**WEST SUSSEX COUNTY COUNCIL
STRATEGIC PLANNING CONSULTATION**

SUBJECT: P/82/12 - Removal of existing workshop & conservatory. Construction of a single-storey rear extension (East). New vehicle access to Pagham Road to provide 'in & out' vehicle movement for safety reasons.

24, Pagham Road, Pagham, West Sussex, PO21 4NP

24 PAGHAM ROAD
PAGHAM
MR. & MRS. CASS
NEW DRIVE/ROOF PLAN
1:100 / 1:250
3207.O1 PL12

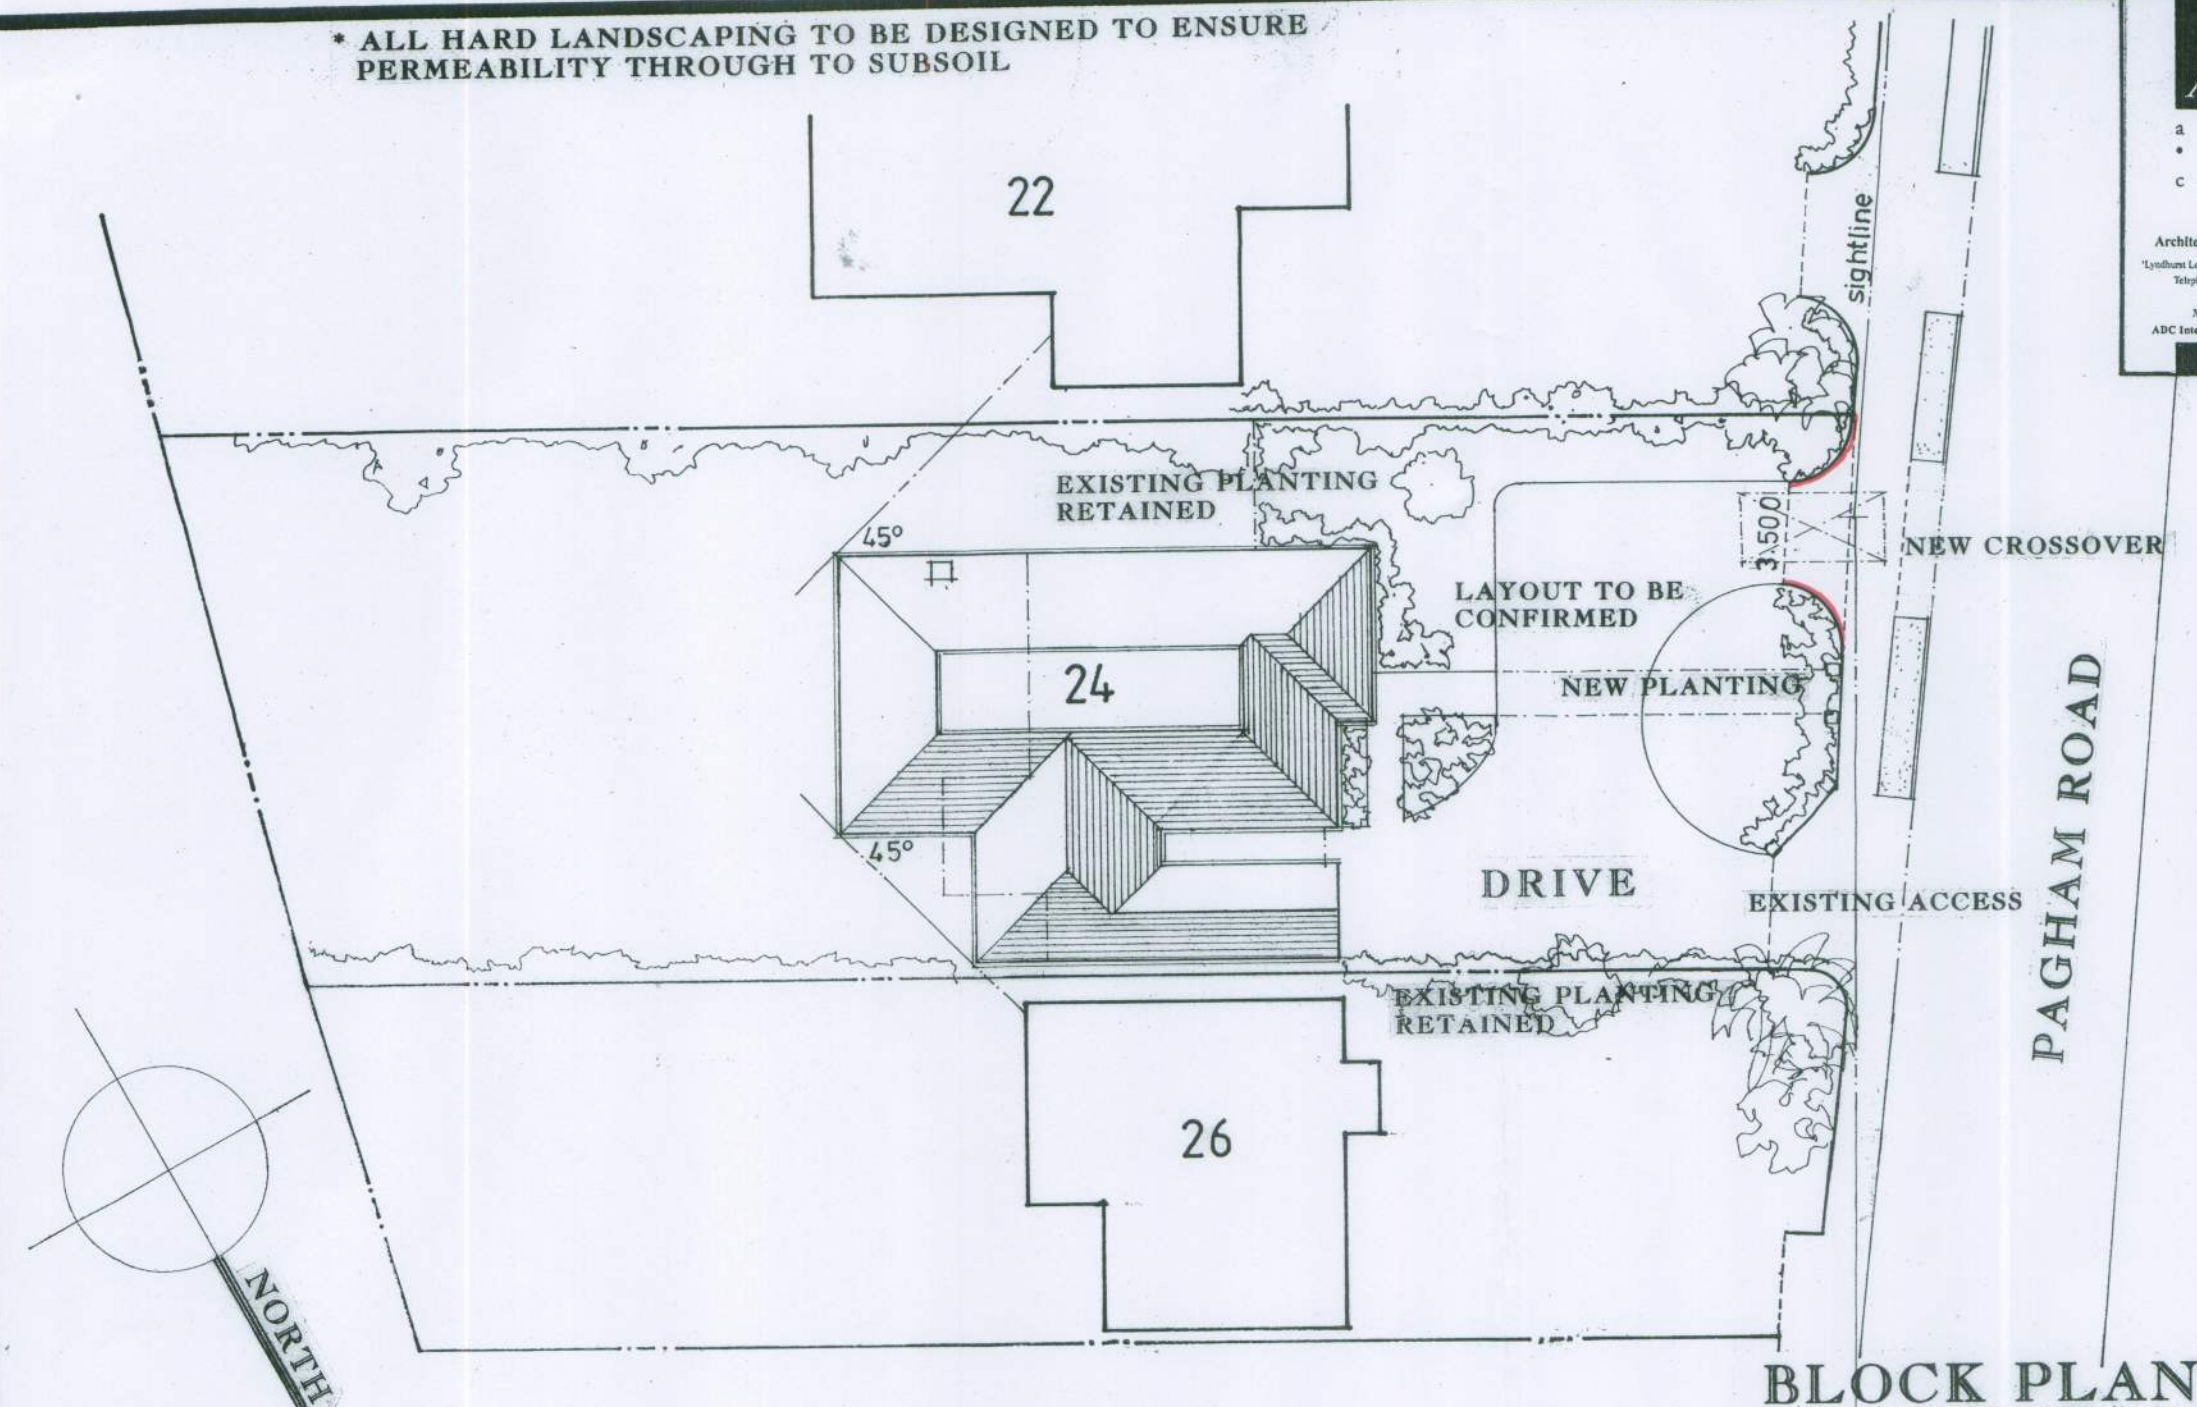
There is no apparent visibility issue at the proposed new access point, and given that an access already exists adjacent to it, would seem sufficient evidence to presume there are no concerns. The site lines to the east when exiting will also be enhanced from having the exit moved. The most recently available verified accident records reveal there have been no personal injury accidents in this direct vicinity. The provision of 2 x 2 metres pedestrian visibility splays should be secured by condition at this access point.

The amount of parking should not be lost within this proposal. Furthermore, the site is situated in a sustainable location, close to a number of bus stops within walking distance.

Based on the above comments, I see no reason to object to this planning proposal from a highway perspective subject to conditions regarding pedestrian visibility and the construction of the access to a highway specification.
